1ST FLOOR WALLS AND CEILING PLAN
SCALE: $\frac{3}{16}$ " = 1'-0"

CLIENT: WHITTENTON BUILDERS
MAIN PROJ. # 25-1-33
SCOPE OF WORK: STRUCTURAL LETTER
ADDRESS: "LONE STAR" PLAN
DATE: 10/17/2025
ENG: CLH

THIS LETTER IS INTENDED SOLELY FOR THE CLIENT LISTED AND ADDRESS. THE PURPOSE OF THIS LETTER IS TO PROVIDE A RECORD OF AN INSPECTION.

APPROVED 10-17-2025

ROOF
FRAMING PLAN

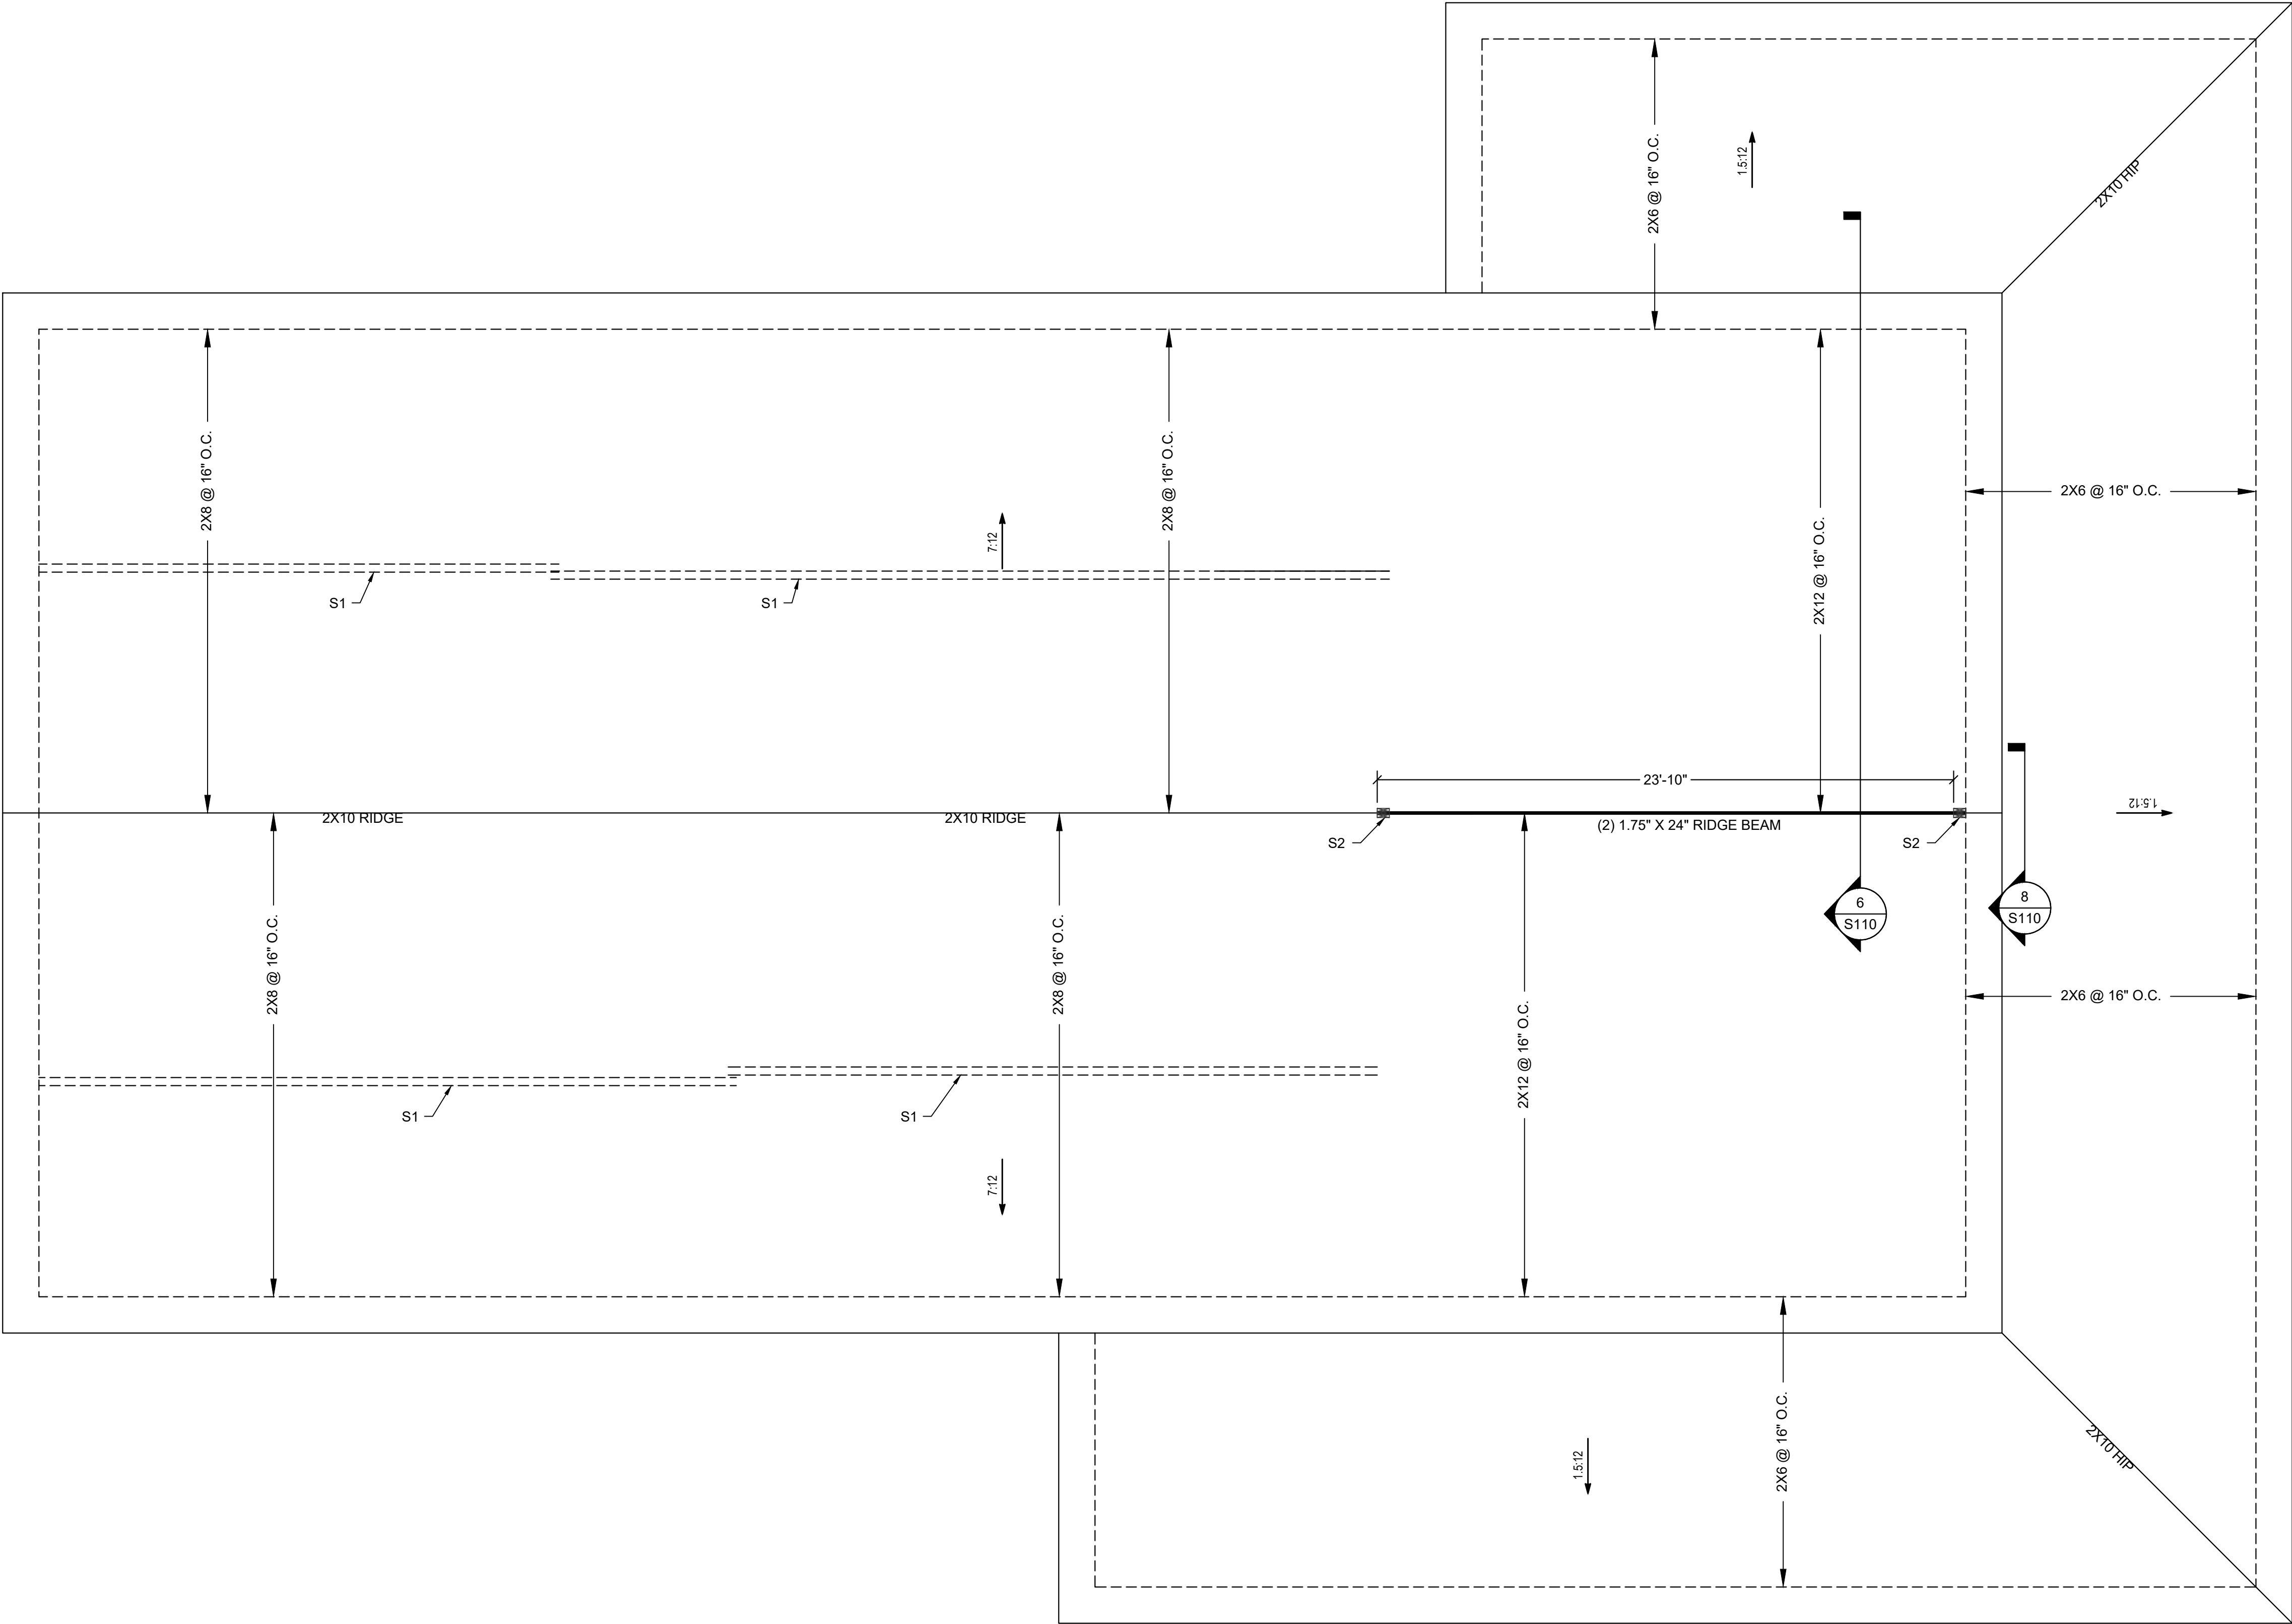
BUILDER NOT REQUIRED TO PUT SIMPSON H2.5A
AT BTM OF KNEEWALL. SHEATHING CONTINUES
DOWN ONTO BEAM / WALL AND NAILED
